From: Laura Gibbons <Laura.Gibbons@arun.gov.uk>
Sent: 10 August 2021 14:05
To: Planning.Responses <Planning.Responses@arun.gov.uk>
Cc: Simon Davis <Simon.Davis@arun.gov.uk>
Subject: RE: Planning Re-Consultation on: BN/98/21/DOC

Engineers Comments Regarding Condition 10

Application No: BN/98/21/DOC

Site Address: Land North of 1 Northfields Cottages Fontwell Avenue Eastergate PO20 3RX
Grid Reference: 494714 106230
Category: Discharge of Condi
Description of Works: Approval of details reserved by condition imposed under BN/50/20/PL relating to conditions

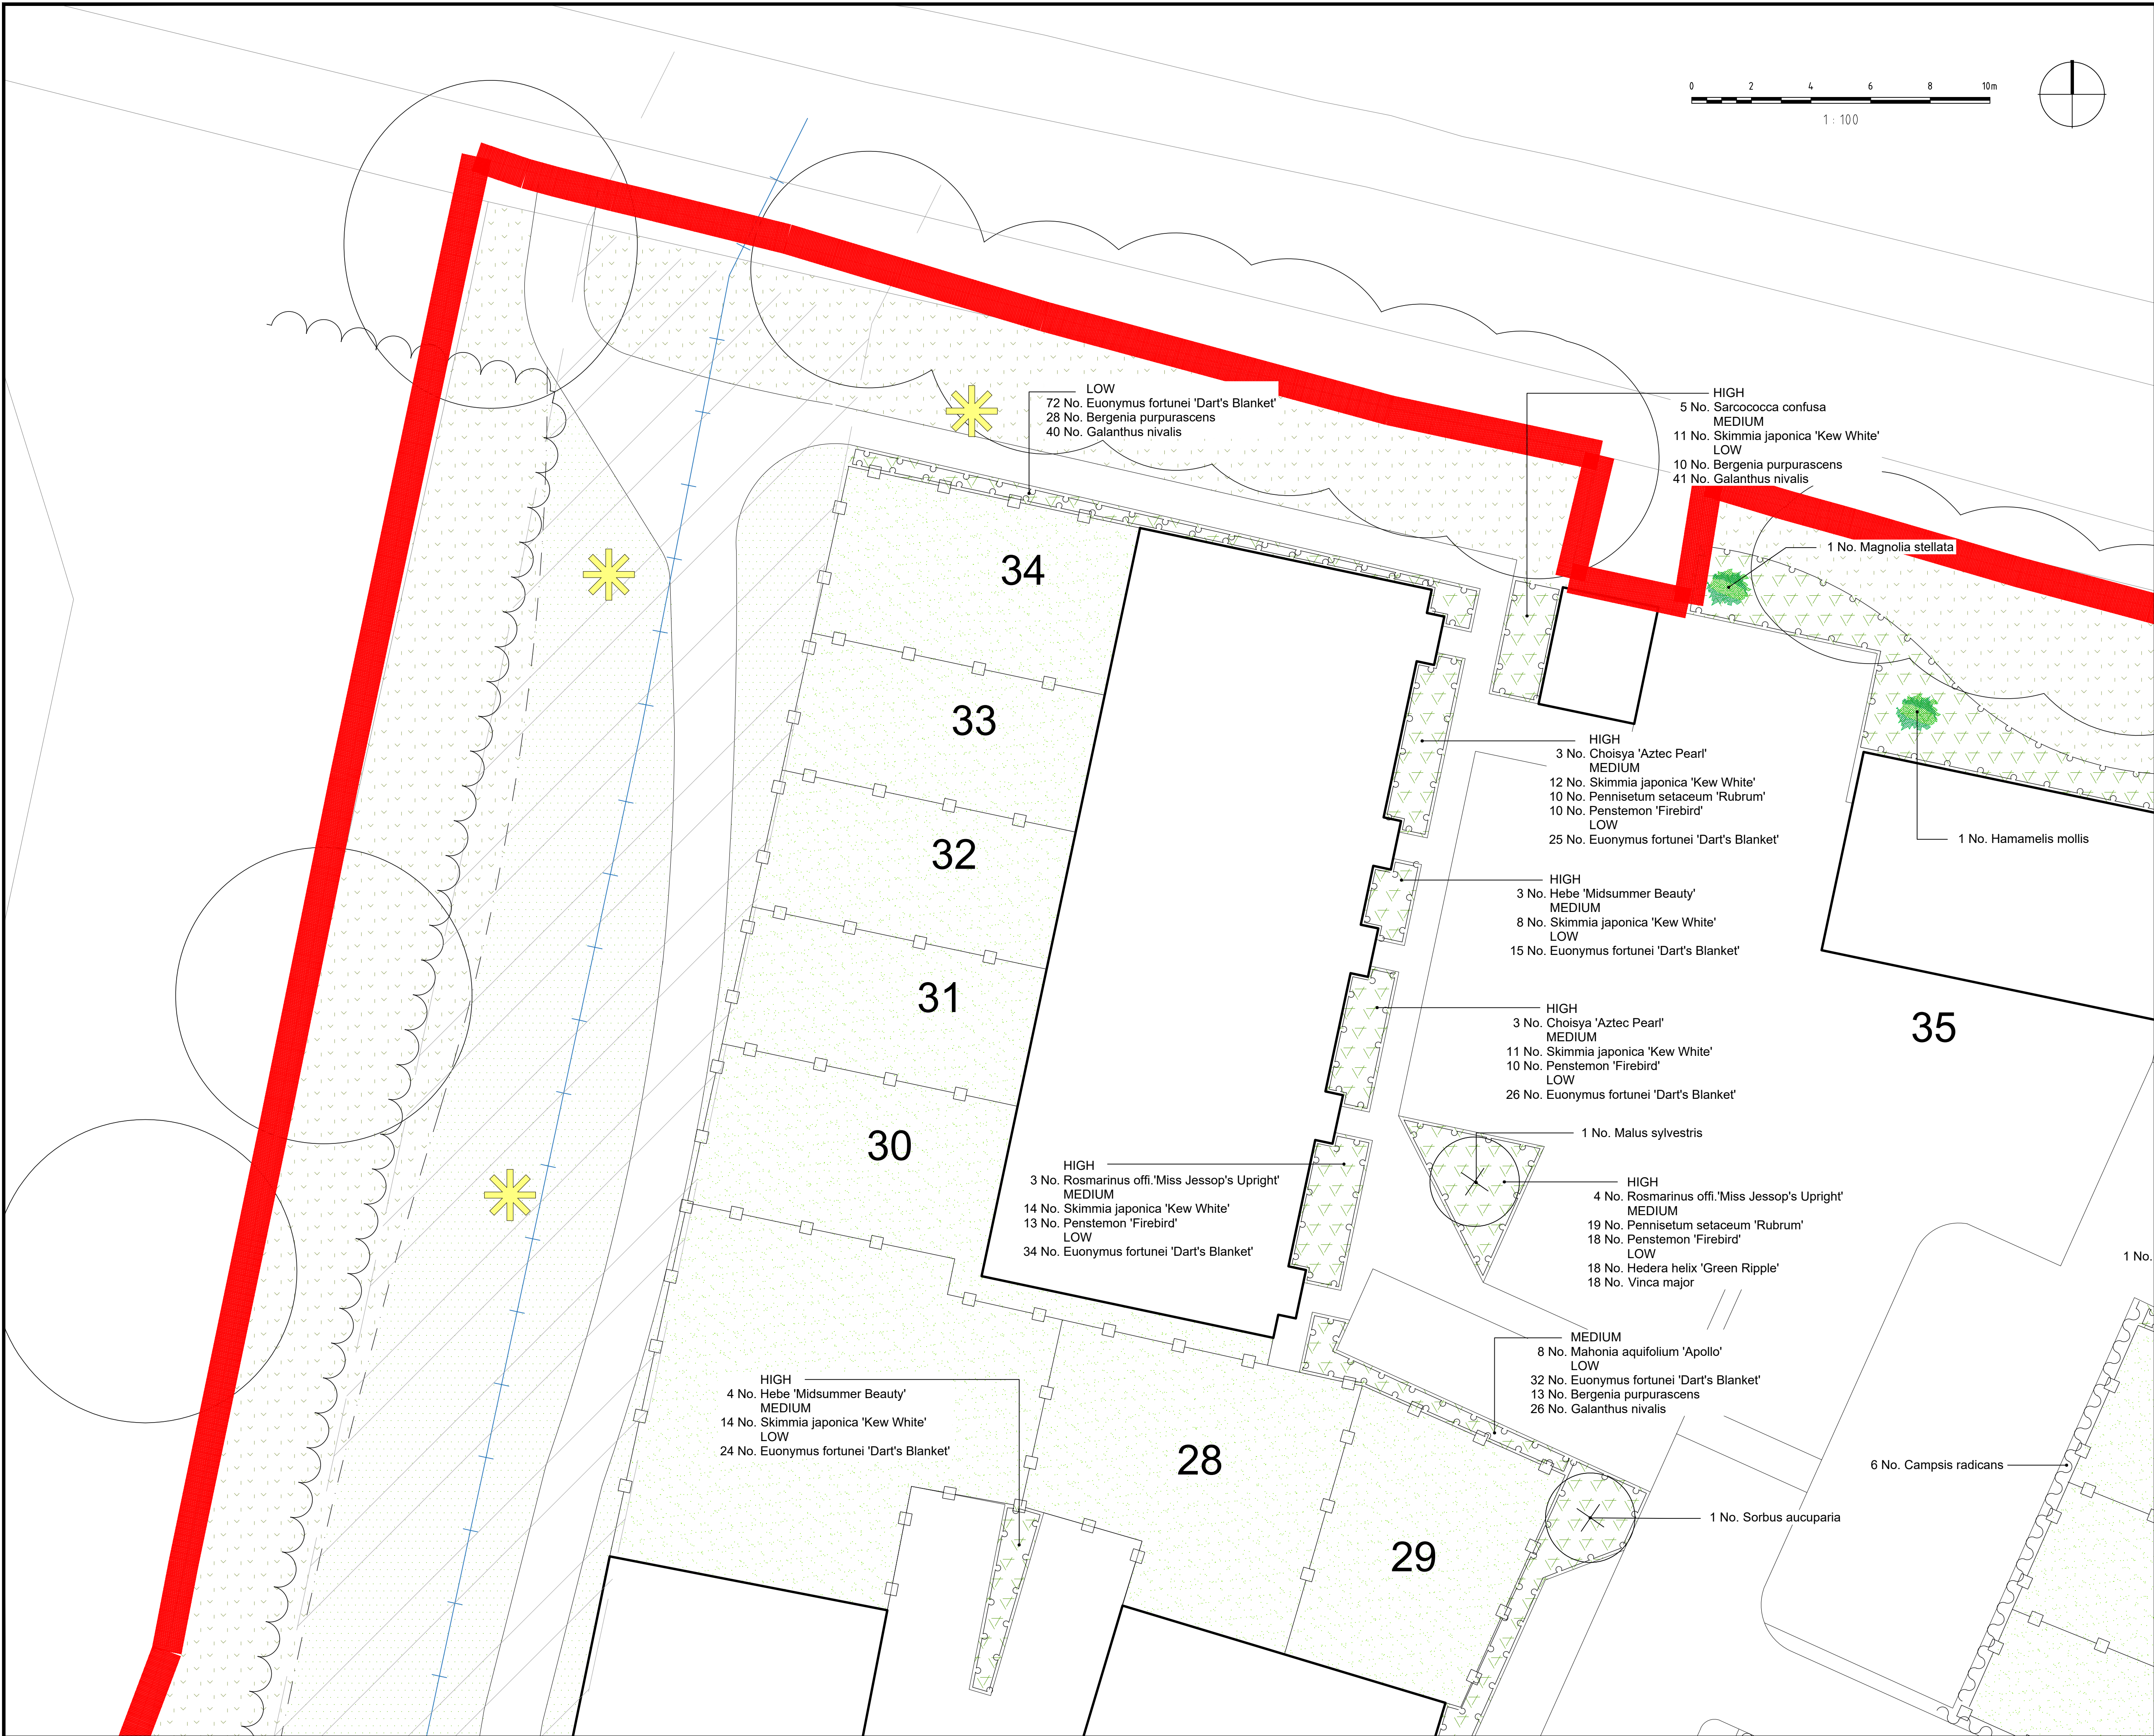
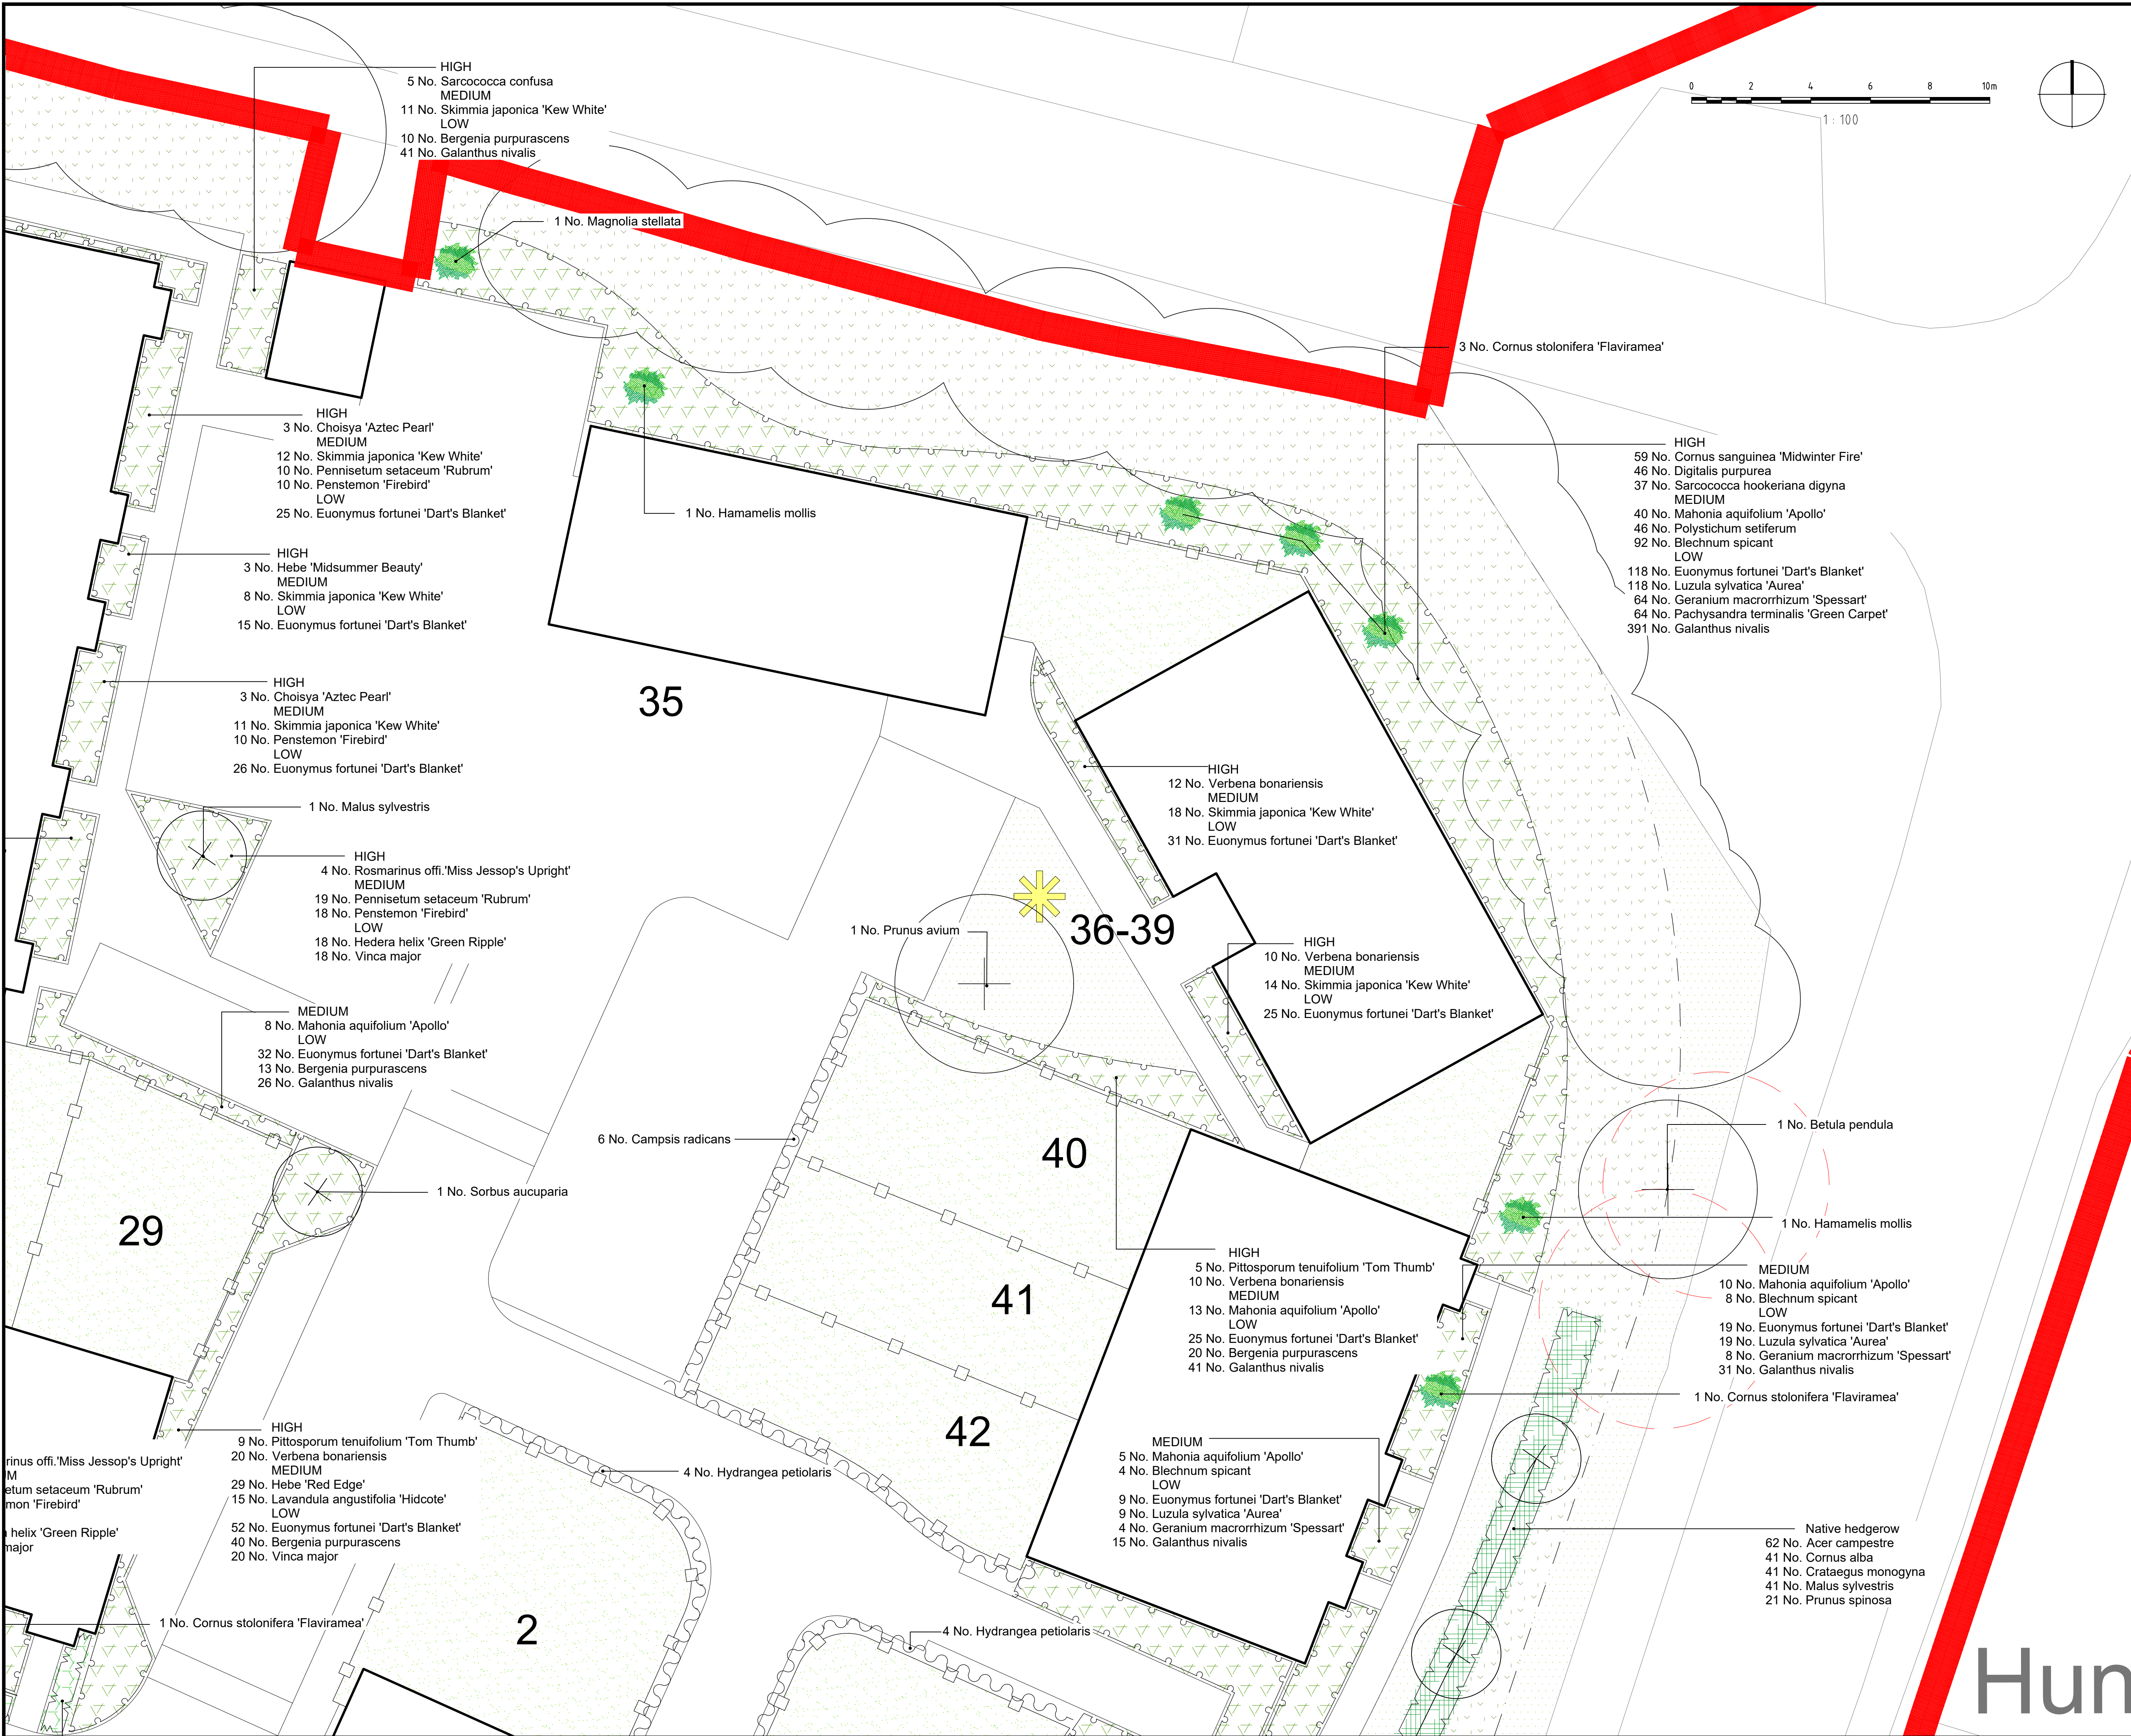
- The drainage layout needs to be more detailed, i.e. include details of the pipe networks e.g. pipe diameters, falls, manhole cover and invert levels, catchpits, etc.
- There is significant conflict between the proposed landscaping plans and the proposed drainage. This must be resolved so that trees are not proposed over pipes or crates.
